Stage 1 Road Safety Audit Response Report

Project No: ITM10127
Project Title: Capitol Park, Leeds
Title: Stage 1 Road Safety Audit – Response Report (Proposed M62 Junction 28 Improvements: Full Works)
Ref: ITM10127-017B TN
Date: 17 October 2022

Report Title:	Stage 1 Road Safety Audit Response Report – Proposed M62 Junction 28 Improvements: Full Works
Date:	17 October 2022
Document Reference and Revision:	ITM10127-017B TN
Prepared by:	i-Transport LLP & Pell Frischmann
On behalf of:	Leeds City Council as the Overseeing Organisation

B	Amendments following Stage 1 RSA	CJO	SME	SME	04.08.22
A	Issue for Planning	AGA	SME	SME	25.07.18
Drawn	AGA	25/07/18	Scale	NTS @ A3	
Designed	AGA	25/07/18	File No.	A13398-T-003 - RevB.dwg	
Checked	SME	25/07/18	Drawing Status	DRAFT	
Approved	SME	25/07/18	Drawing No.	A13398-T-003	Revision
					B

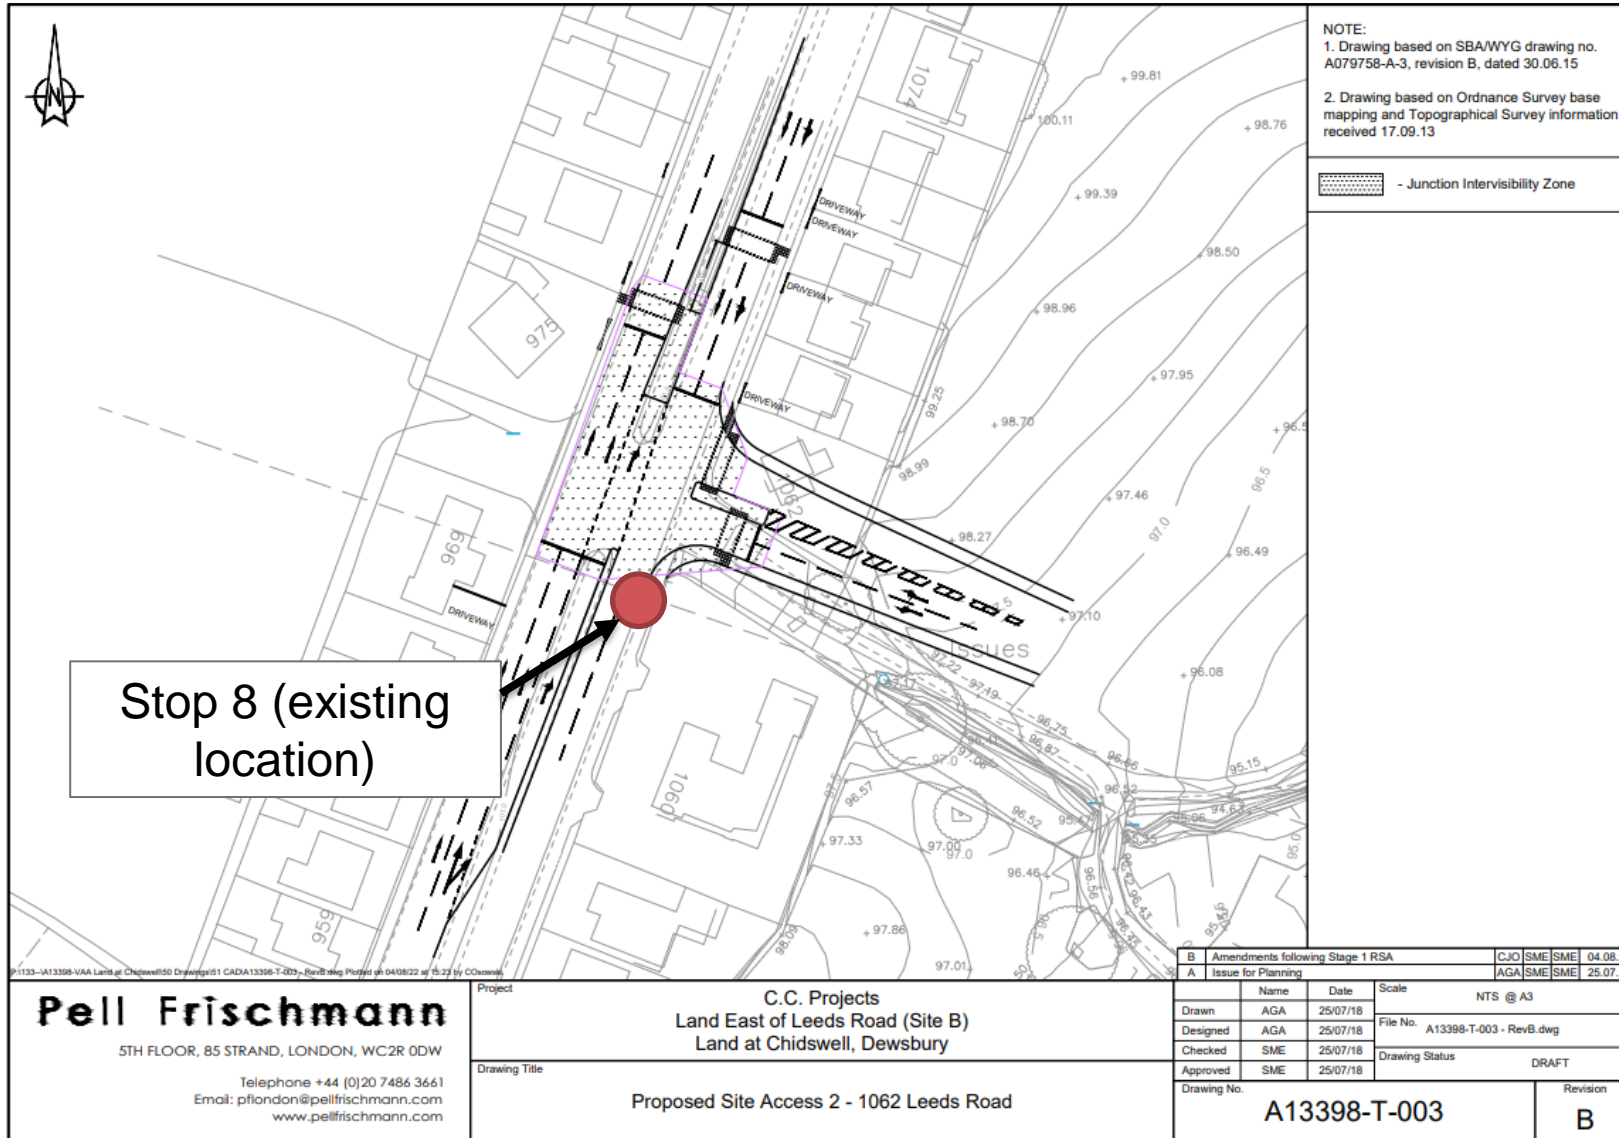
Ref:	RSA Problem	RSA Recommendation	Design Organisation Response	Overseeing Organisation Response	Agreed RSA Action
3.2	<p>Location: The Dewsbury Road northbound approach to the roundabout.</p> <p>Summary: The nearside lane marking could confuse motorists and increase the risk of collisions.</p> <p>The nearside lane worded destinations are correct (A650 and M62), but the arrow shows the lane as left-turn only. Motorists, particularly those unfamiliar with the area and intending to access the M62 west, could be led to believe that they should stay in the nearside lane, then brake and manoeuvre suddenly at the A650 exit to regain the correct lane on the circulatory on their offside. This could increase the risk of tail-end or side-swipe collisions with following motorists in that lane.</p>	<p>It is recommended that the left-turn arrow is replaced with a double-headed straight-ahead and left-turn marking.</p>	<p>The recommendation is accepted. The nearside lane marking has been amended in Revision H of the scheme drawings, enclosed at Appendix A.</p>	<p>The recommendation is accepted</p>	<p>Nearside land marking amended.</p>
